**Re: No 4 Frederick Street, St Leonards - Northside Mental Health Facility
(your ref: SSD – 7588) (10 Herbert Street St Leonards - Lot 2 DP 12112720)**

SUBMISSION - PROPOSAL FOR NORTHSIDE MENTAL HEALTH FACILITY (YOUR REF: SSD – 7588)

1 ELEVATION WEST
1:100

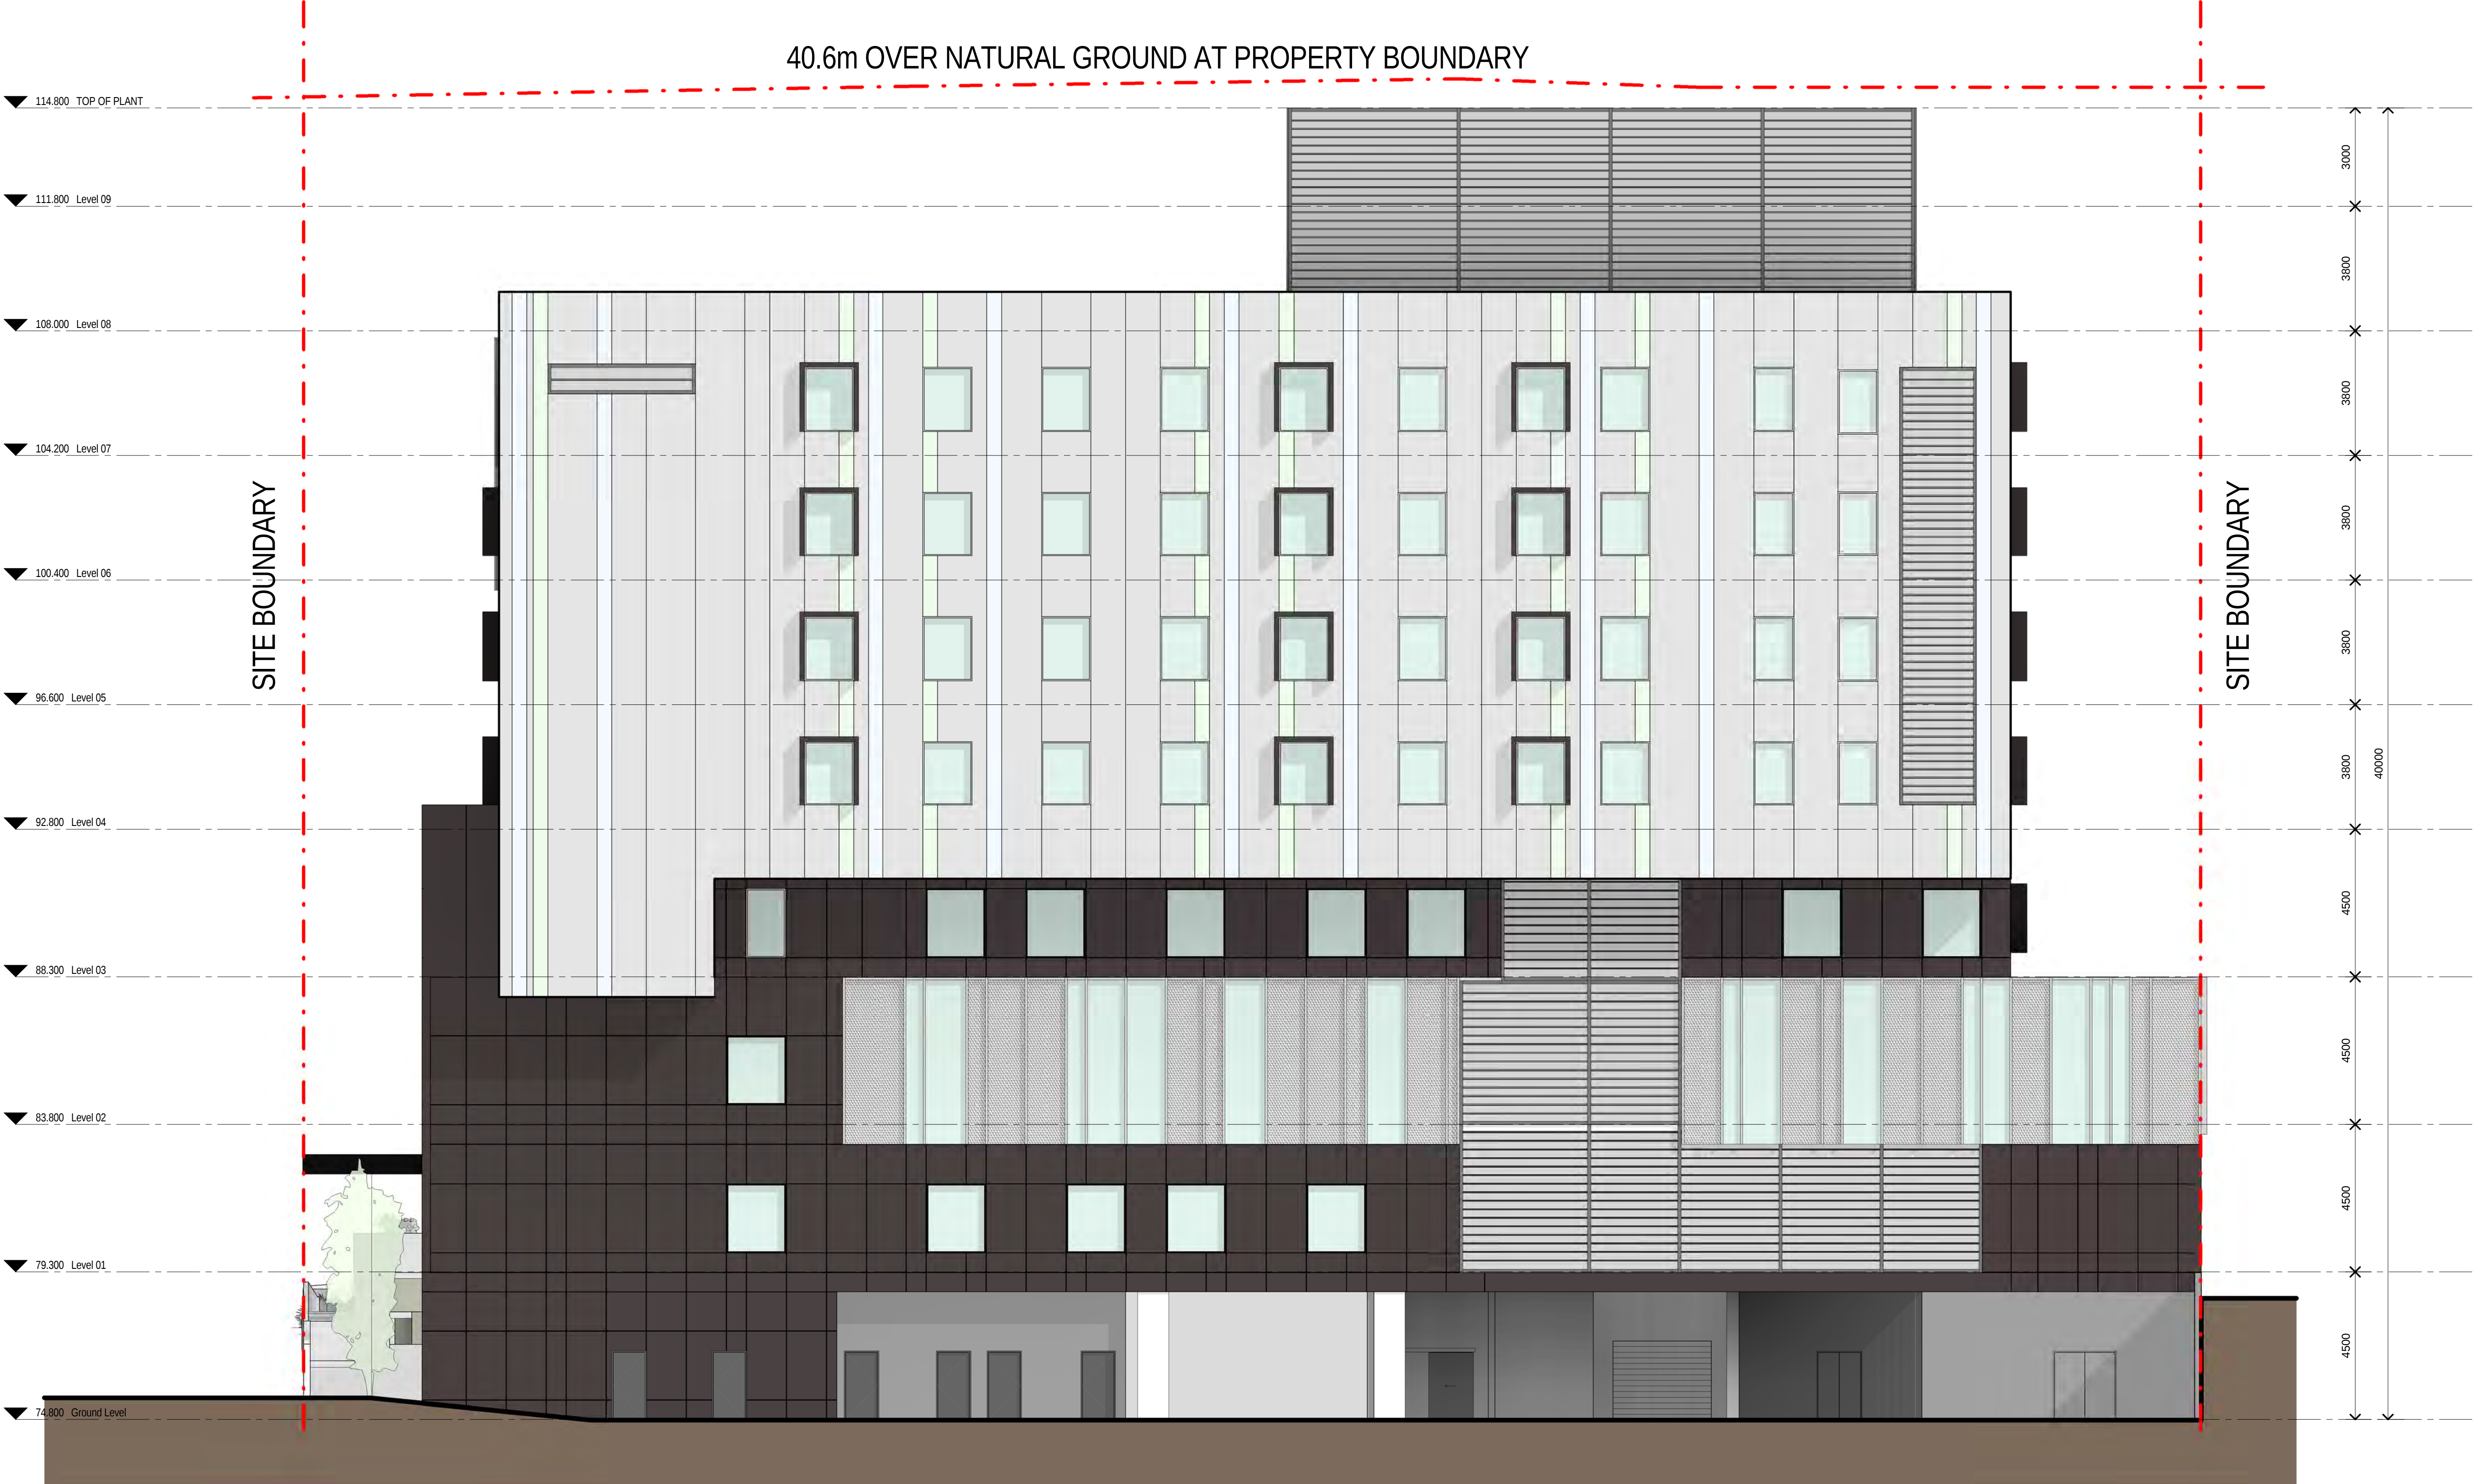
The proposed L-shaped built forms provide a visually interesting forecourt addressing Frederick Street. However, the proposed building has limited setbacks and building modulation along its south-eastern and western elevations. Considerations should be given to a podium – tower treatment to the proposed built forms to allow for a better transition of scale between the proposed building and surrounding developments. A podium level will also provide additional outdoor spaces and improved outlooks and amenity for rooms facing the side and rear elevations over adjoining industrial developments.
